CITY OF ALBUQUERQUE

September 12, 2024

**RE: Residence Inn at Highlands
Grading & Drainage Plans
Engineer's Stamp Date: 08/27/2024
Hydrology File: K15D034D**

Based upon the information provided in your resubmittal received 09/03/2024, the Grading & Drainage Plans are **not** approved for action by the Development Facilitation Team (DFT) on Site Plan for Building Permit.

210046 PROJECT NUMBER C100 SHEET NUMBER

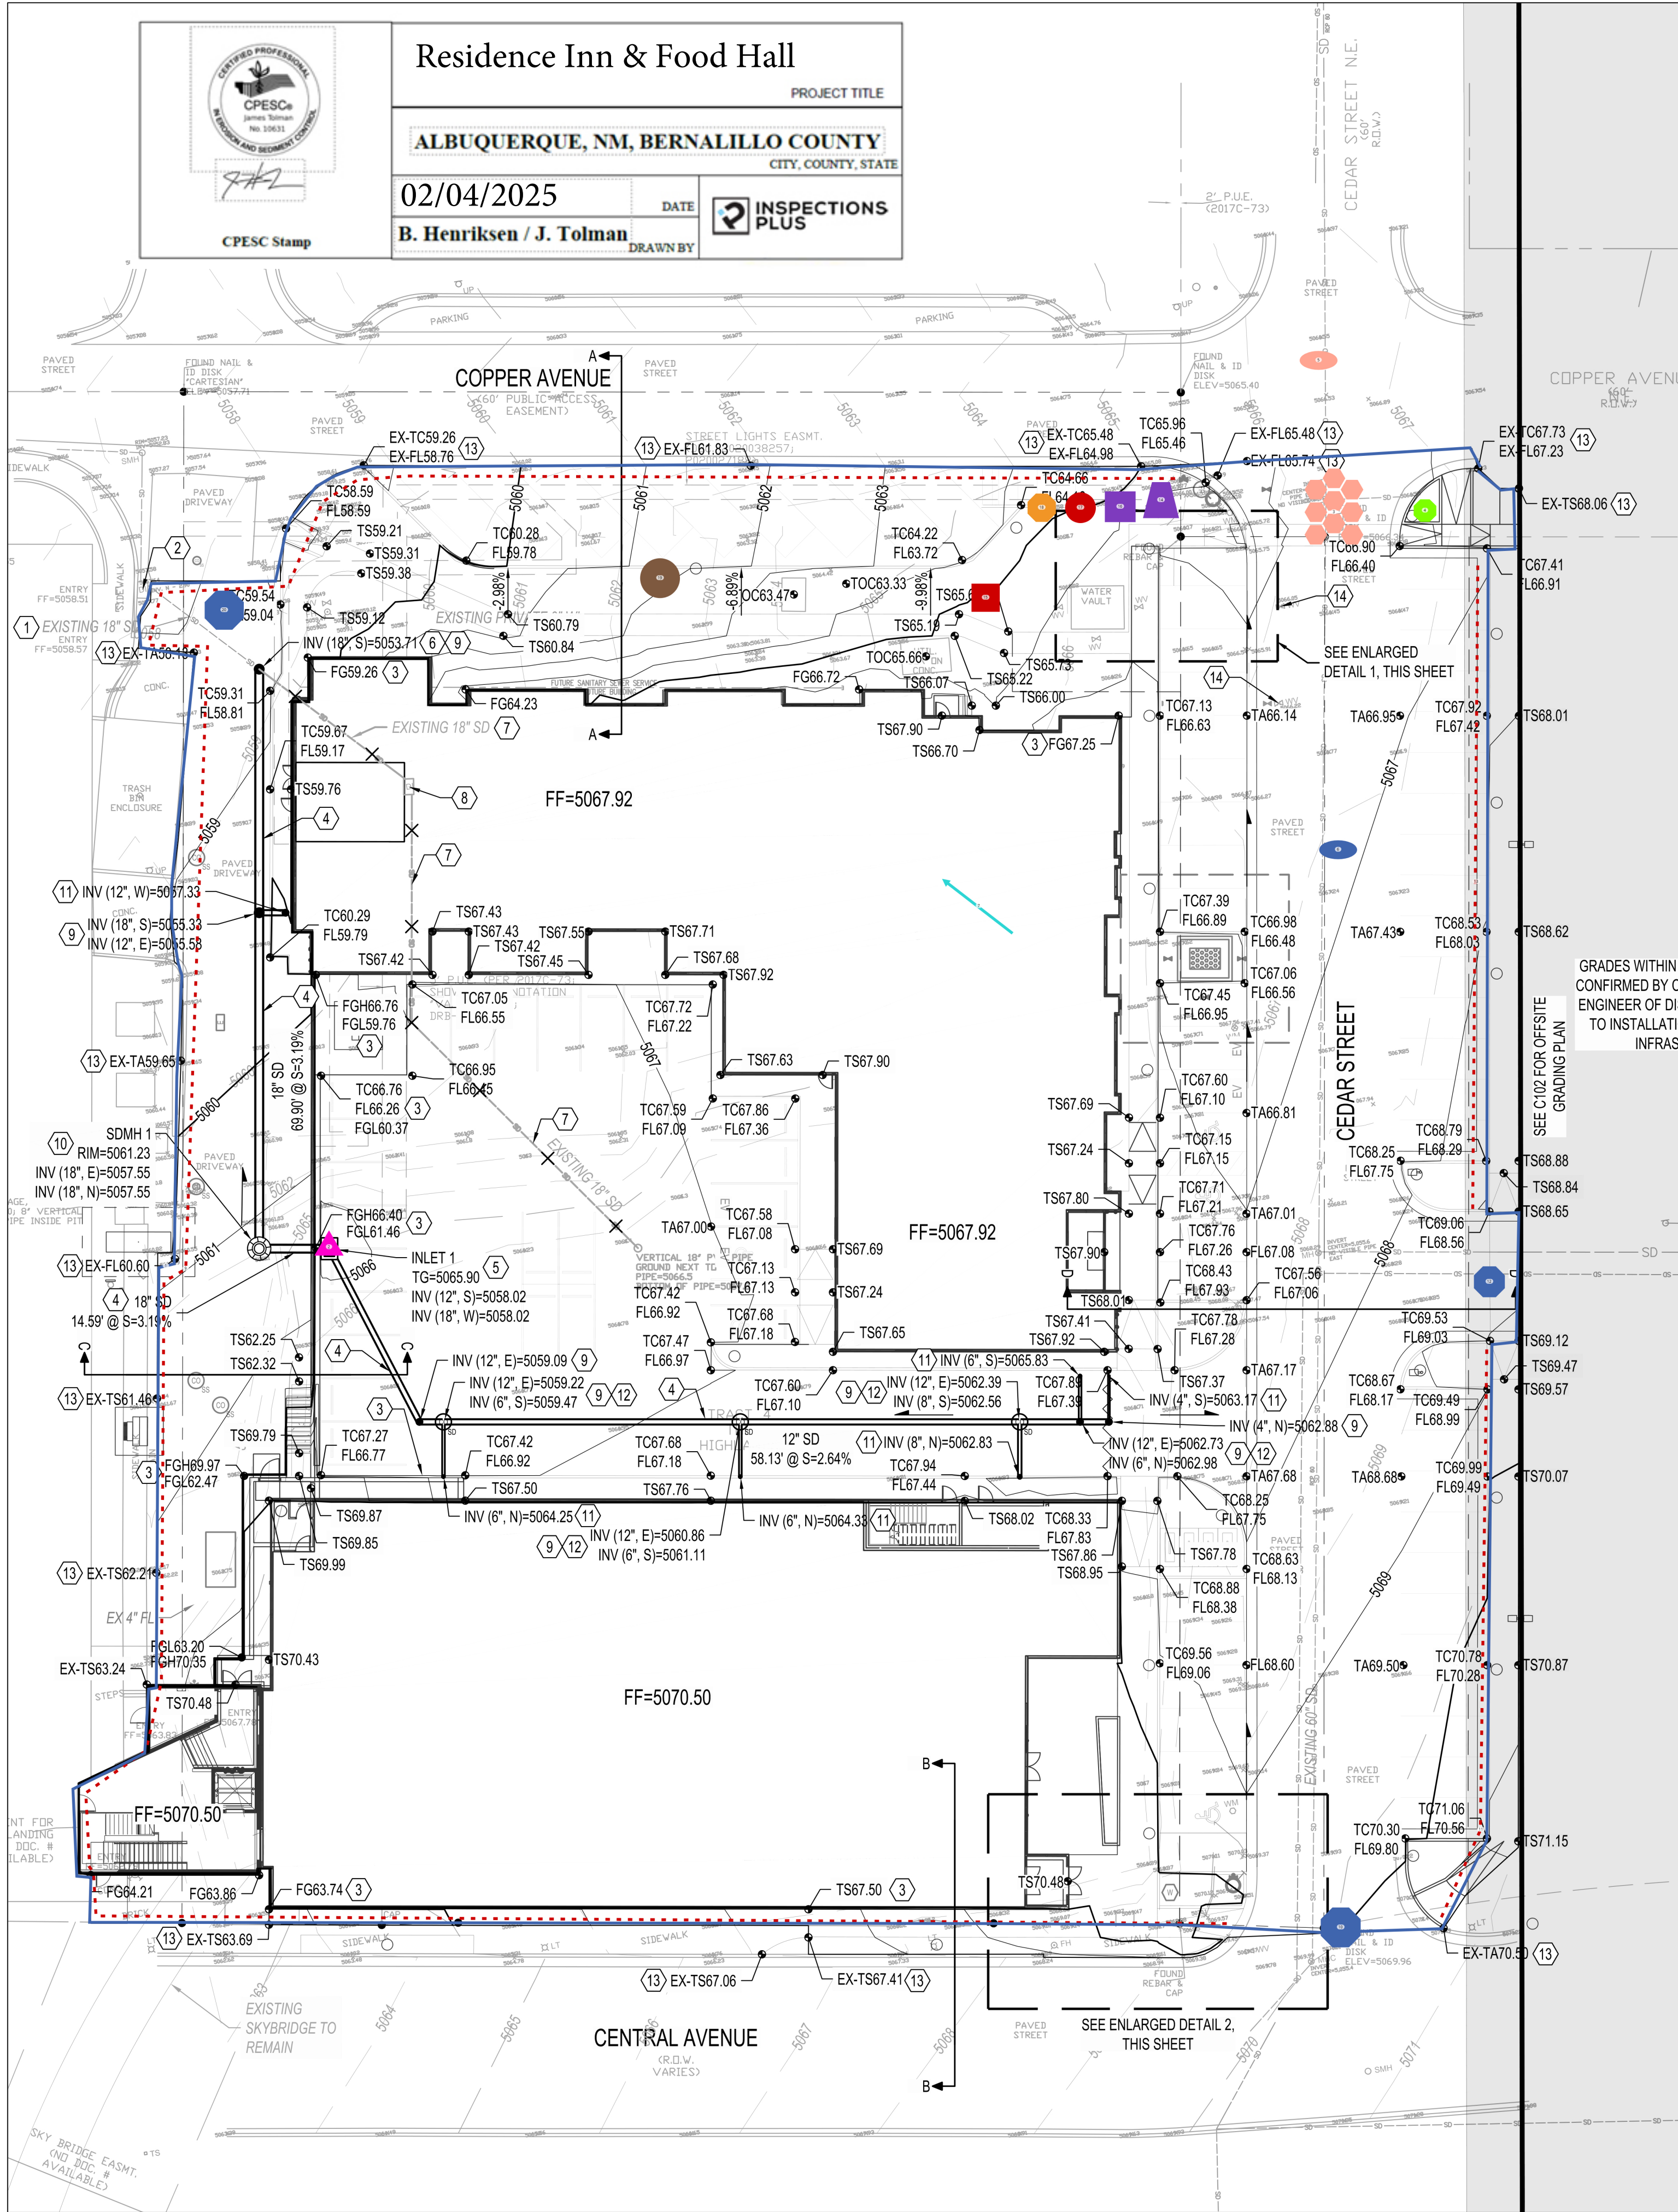
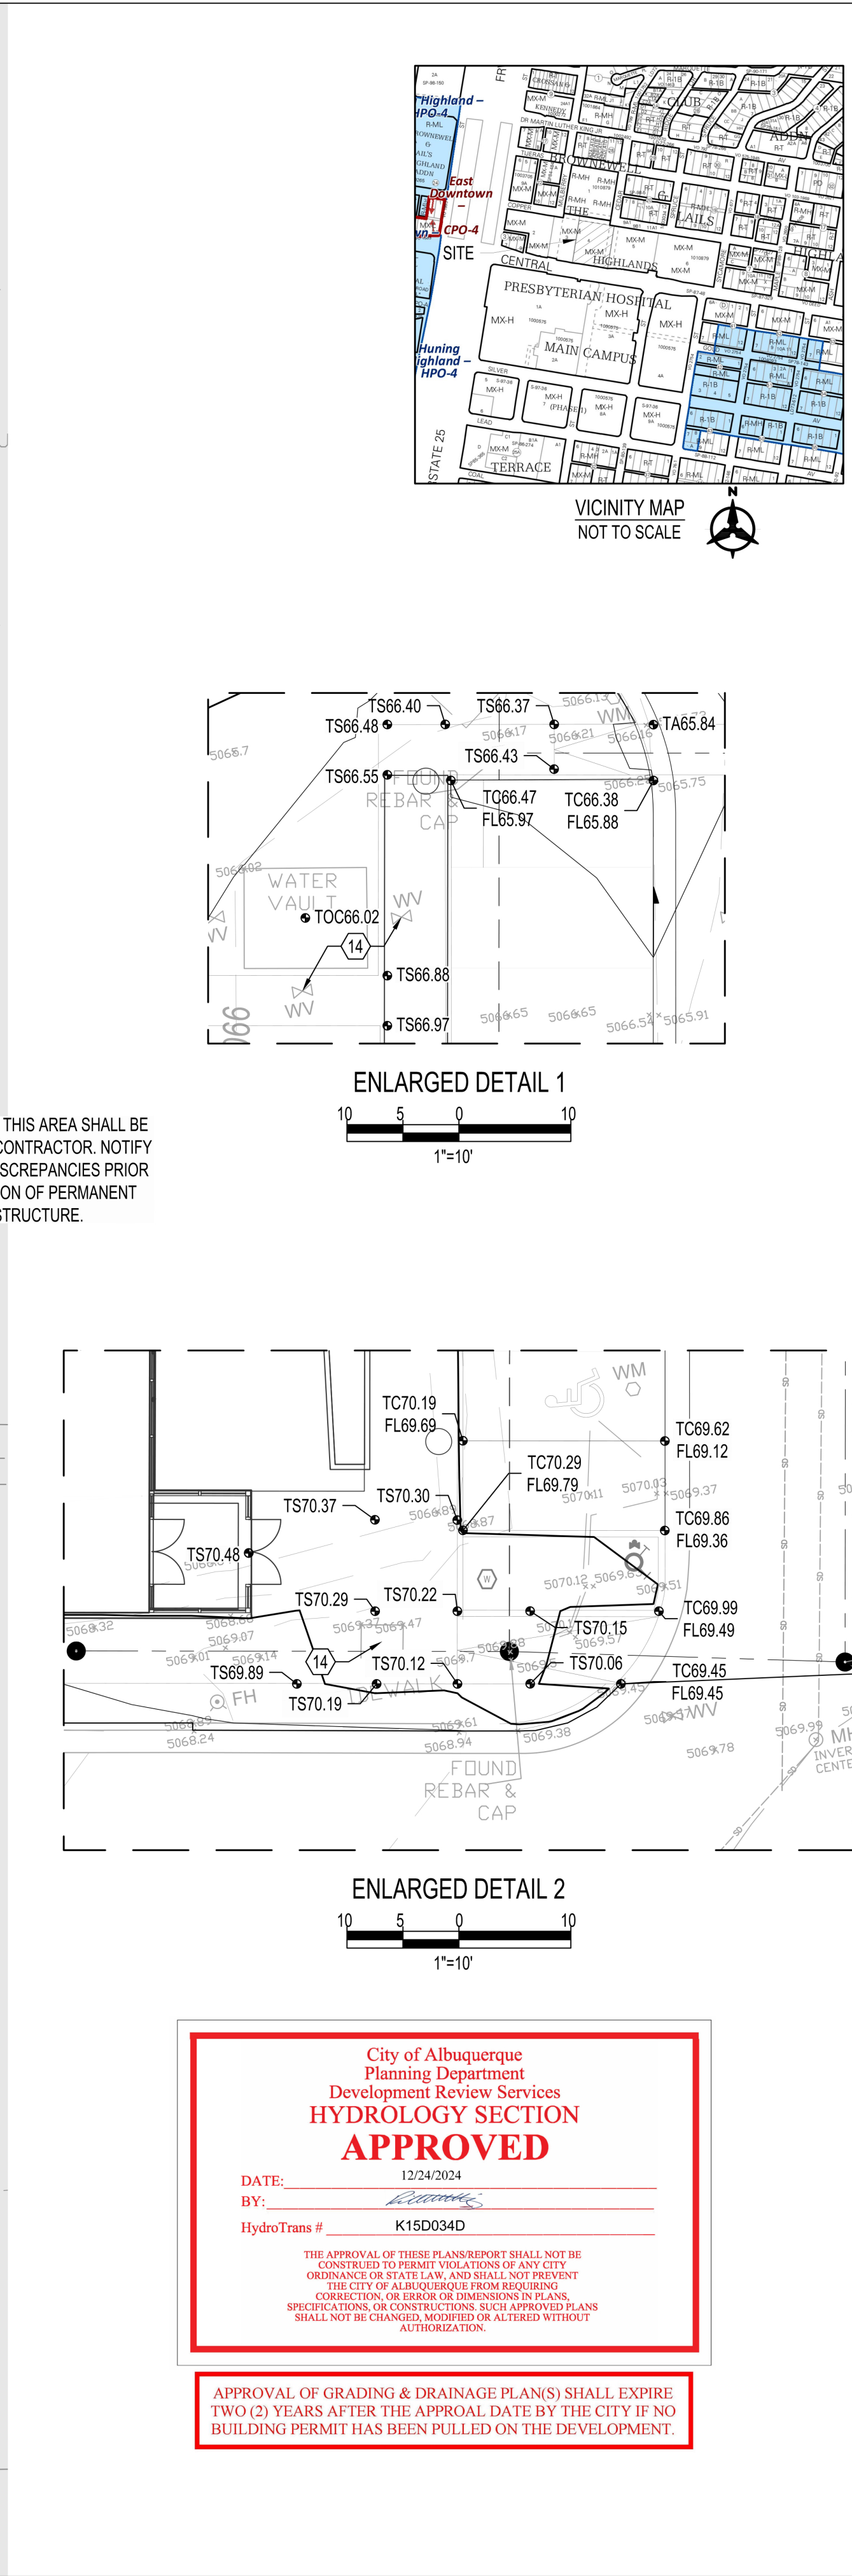
3. Sheet C-100, The existing 21" SD and 60" SD shown on Sheet C-001 should be identified for removal or to remain.
4. Provide management onsite for the Stormwater Quality Volume (SWQV) in accordance with the new drainage ordinance, § 14-5-2-6 (H) enacted 10/2/18 (Council Bill C/S O-18-2), and include calculations of required volumes to be accounted for.

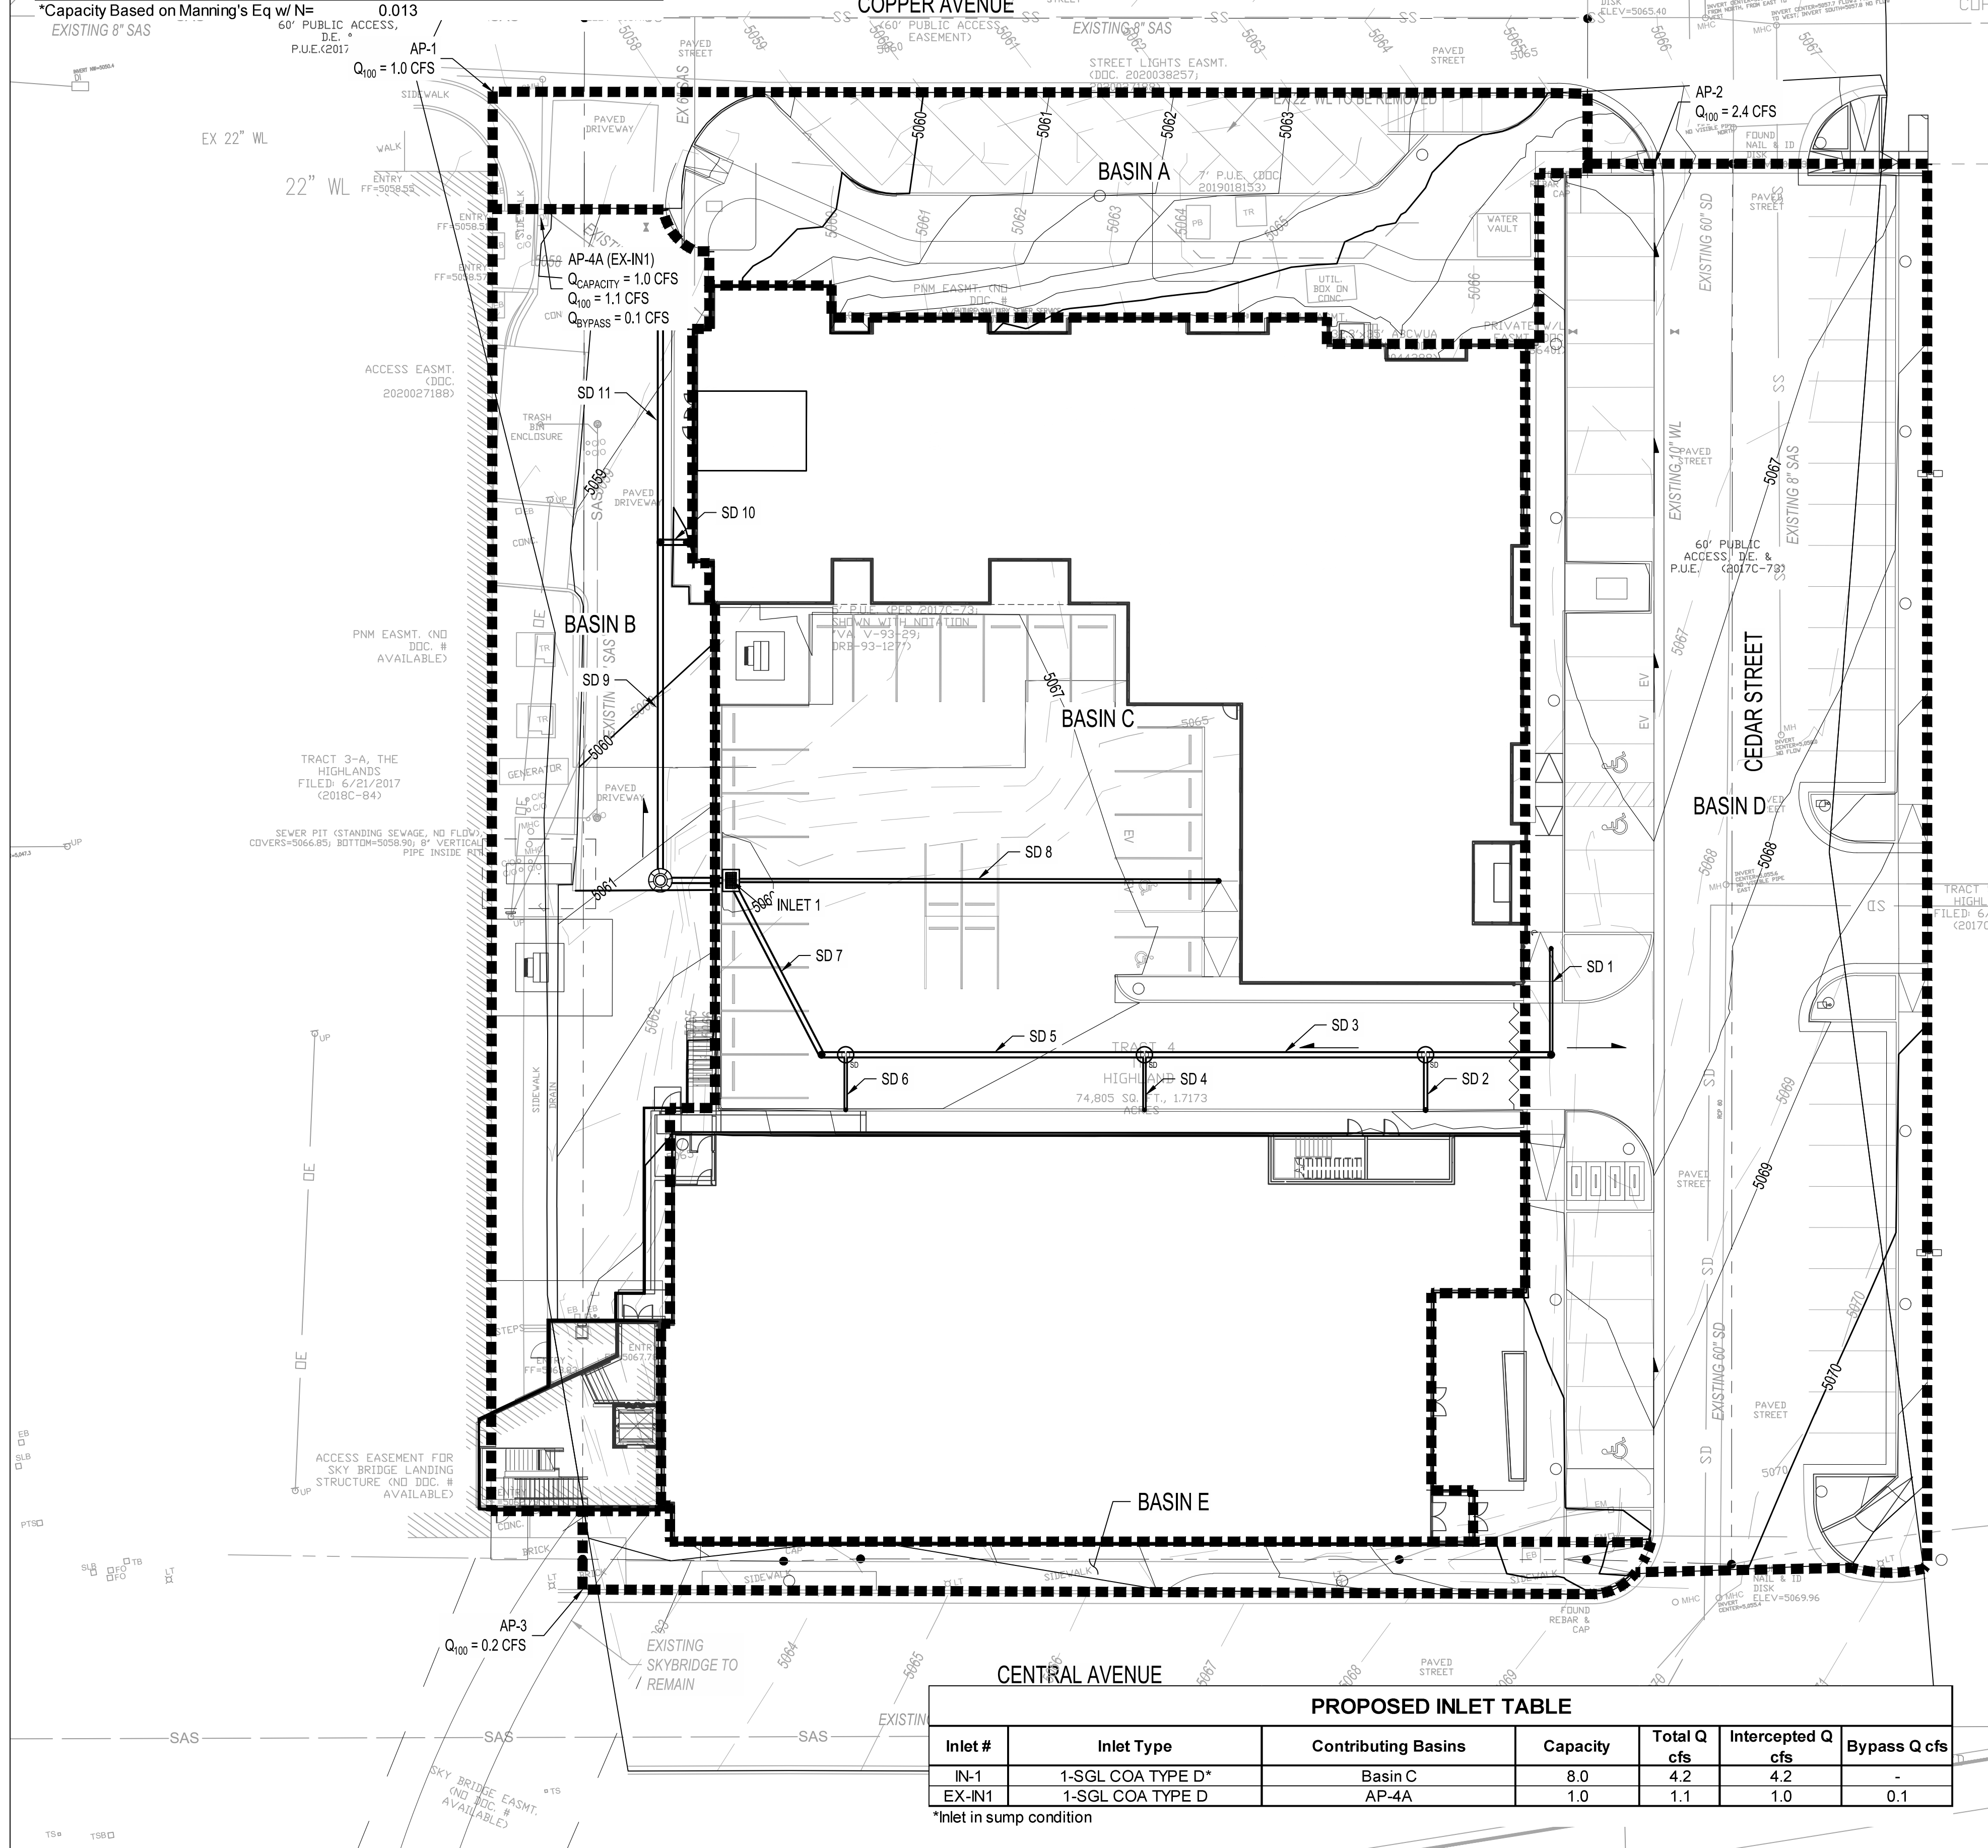
1. Sheet C-001, The Drainage Narrative for **Existing Conditions** and **Proposed Conditions** - Analysis Points do not match the information provided on the Plan Sheets, and should be reviewed and revised accordingly.

2. Sheet C-001, Q for **Proposed Conditions** at existing inlet, NW area of project will be overloaded, should be reviewed and revised to show accurate overflow Q into public R/W.
